**RE: Notice of Exhibition – Modification Request 1 Catherine Field Primary School (SSD 9477)**

**PROPERTY: O'Keefe Drive ORAN PARK  
LOT: 1001 DP: 1234527**

**Figure 6 | Proposed revised layout (Source: Applicant's Modification Application 2020)**

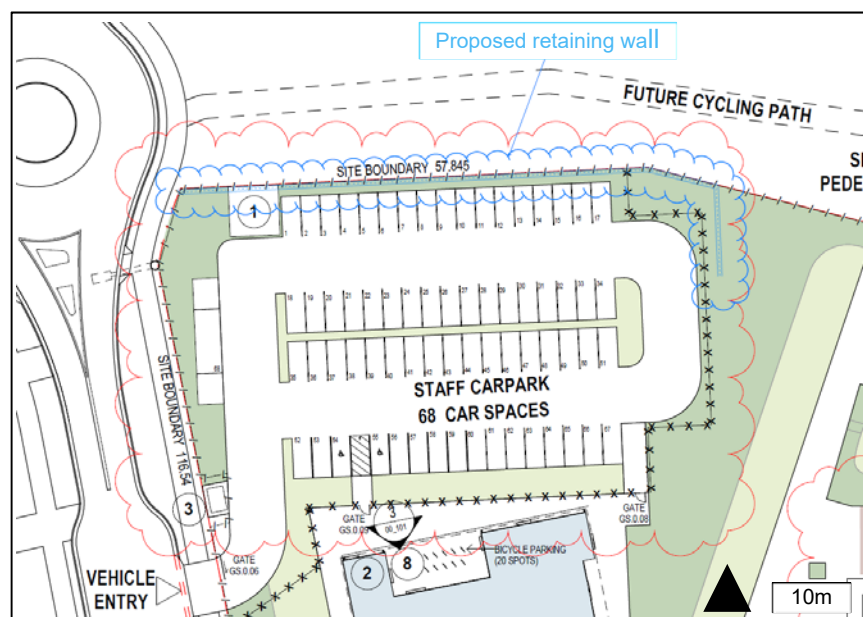
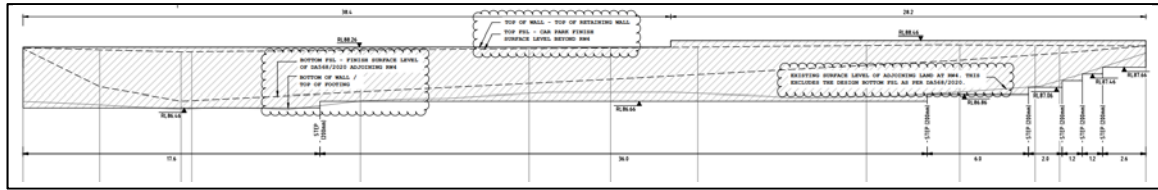
As indicated by the plans for Mod 2, the applicant’s intention is to provide an access point from the adjoining sporting field access (known as LS1) into the school car park. It appears the retaining wall will be around 1.4m tall in the area of the access way and future footpath (no chainages provided in the Engineering plan to confirm the exact wall height around the future area).

The location of retaining wall should be revised to be entirely consistent with the location of the retaining wall proposed in Mod 2 which allows for vehicular and pedestrian access to and from LS1.

The plans do not indicate the materials to be used for the retaining wall. Council suggests the use of sandstone block retaining walls consistent with other retaining walls in the locality. Timber should not be utilised.

The height of the retaining wall may require a balustrade to comply with the BCA or traffic barrier given the proximity to the car park on the adjoining site. Council encourages the Department to seek that the retaining wall be terraced to remove this requirement and make the wall safer (the minimum distance between any step in the retaining wall should be 1 m measured horizontally). Especially given that the retaining wall is in close proximity to a kiss and drop area and a playing fields car park where high numbers of children will be located. If required, details of any required balustrade should be submitted.

The plans of the retaining wall show the wall along the boundary of the site. The wall must be entirely located within the subject site including all associated drainage and backfilling. Council would appreciate if the following standard Camden Council condition of consent could be imposed on the modified consent:
